REQUEST

Current Zoning: ML-2 (Manufacturing & Logistics 2)
Proposed Zoning: ML-1(CD) (Manufacturing & Logistics 1, Conditional)

The petition proposes to develop a vacant, wooded parcel along Interstate 77 with a 165,000 square feet retail goods showroom.

PLANNING STAFF REVIEW

TECHNICAL
DATA SHEET
RZP-2025-061

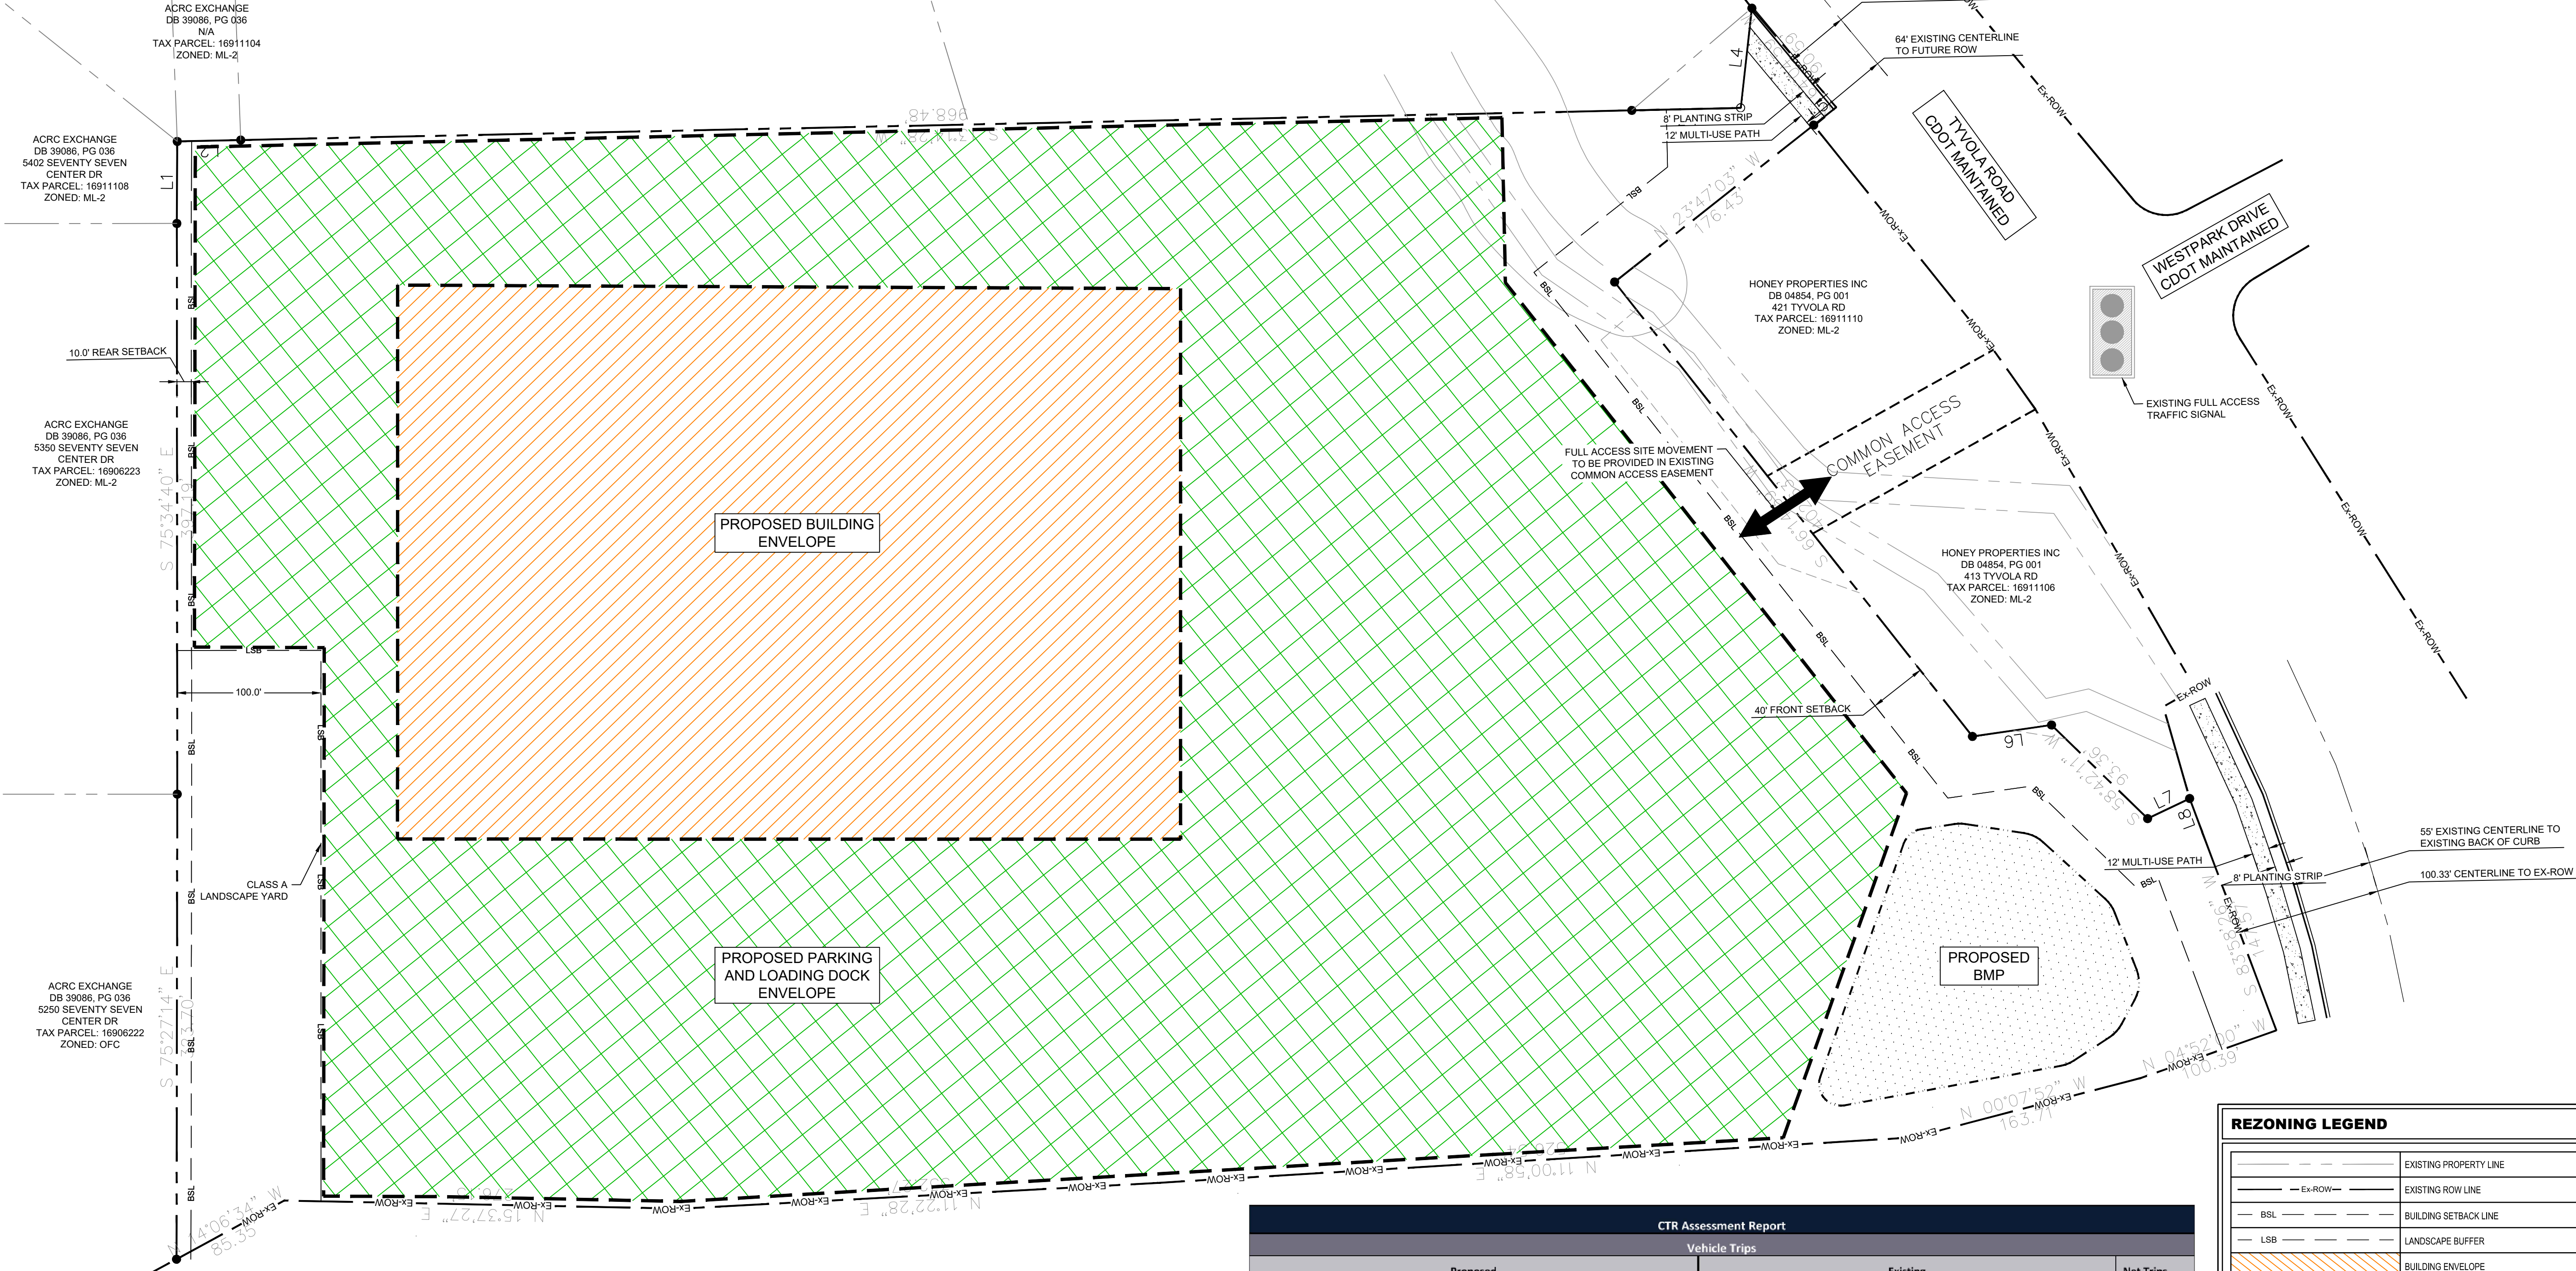
1. Revise tree survey to include all trees in the right-of-way along Tyvola Road.
